FW: BR/31/26/PD

Drawing
Proposed floor plans with dims

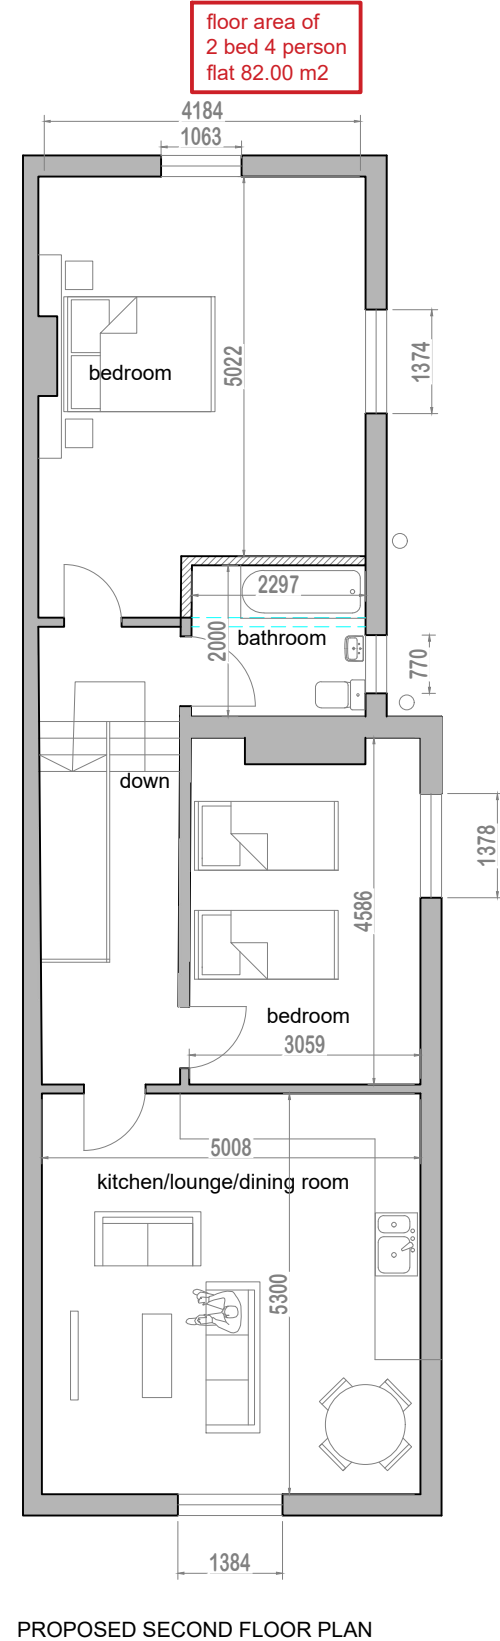
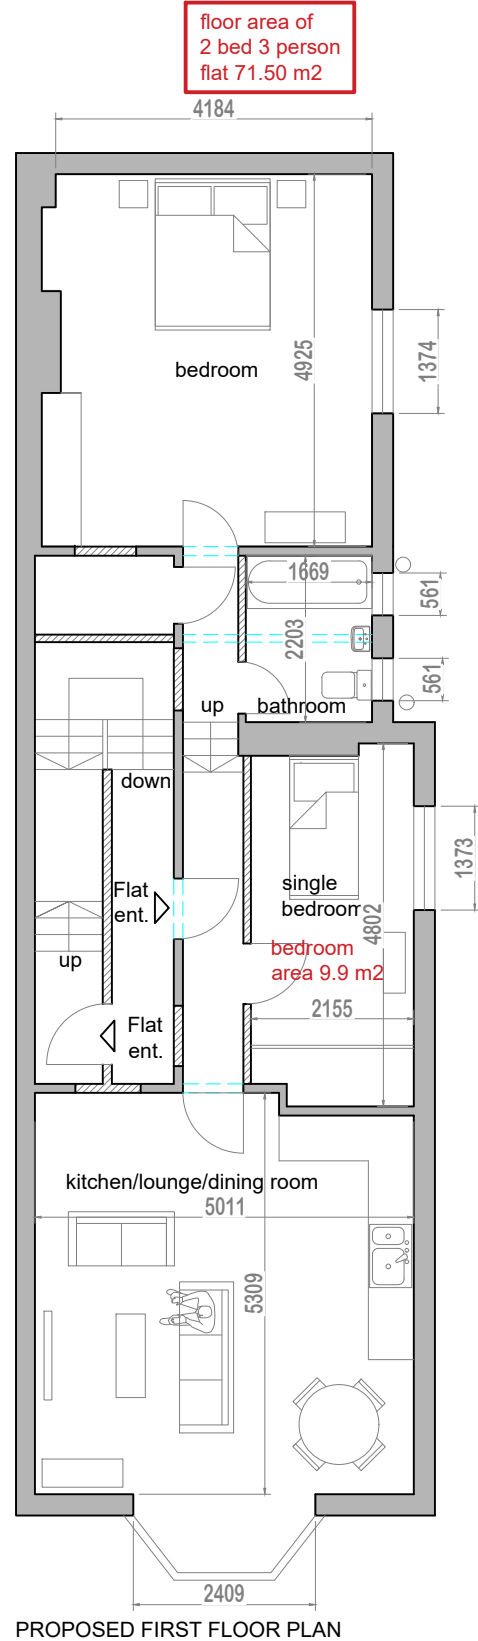
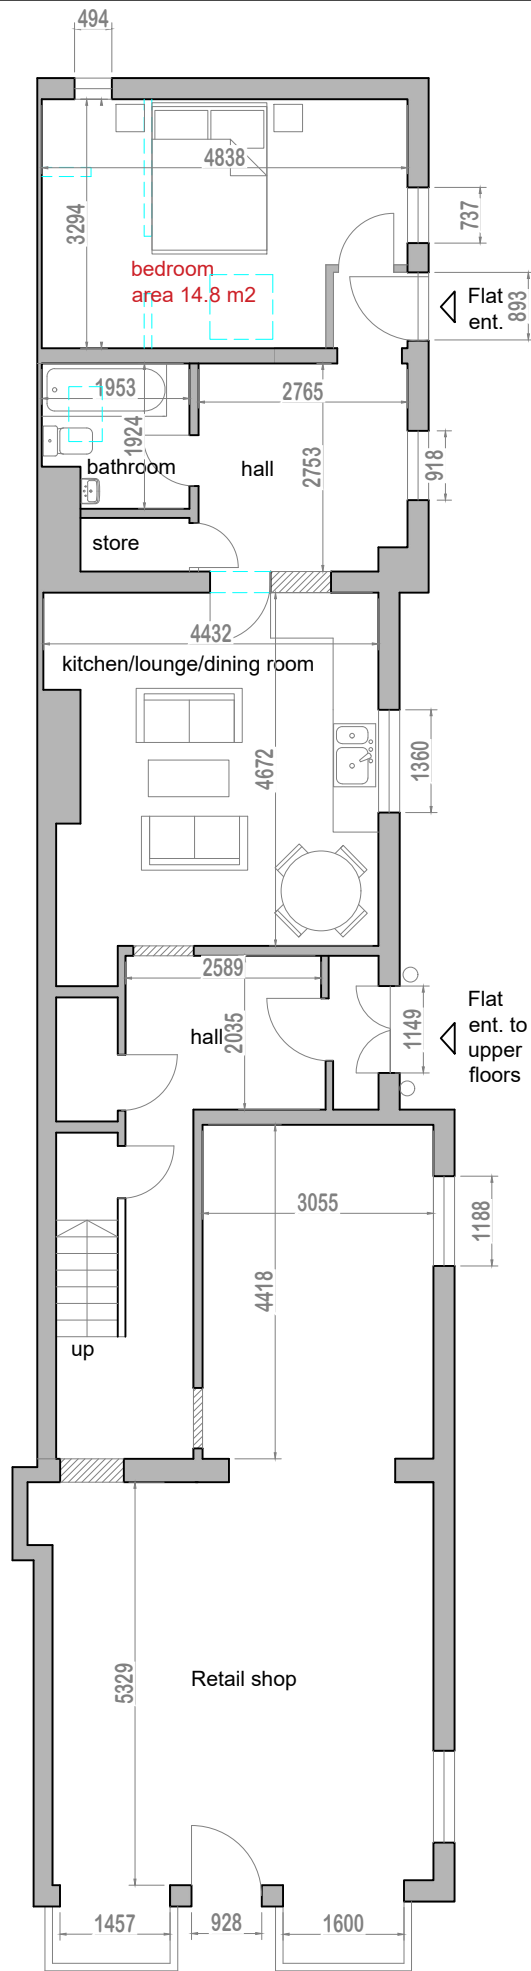
On initial review of the plans, I note that a second-floor side window serving the proposed double bedroom is missing from the existing and proposed floor plans.

From arial imagery, I note 2 roof lights serving the ground floor, these are missing from the existing and proposed floor plans.

Please amend the plans to show:

Second floor window

2 rooflights
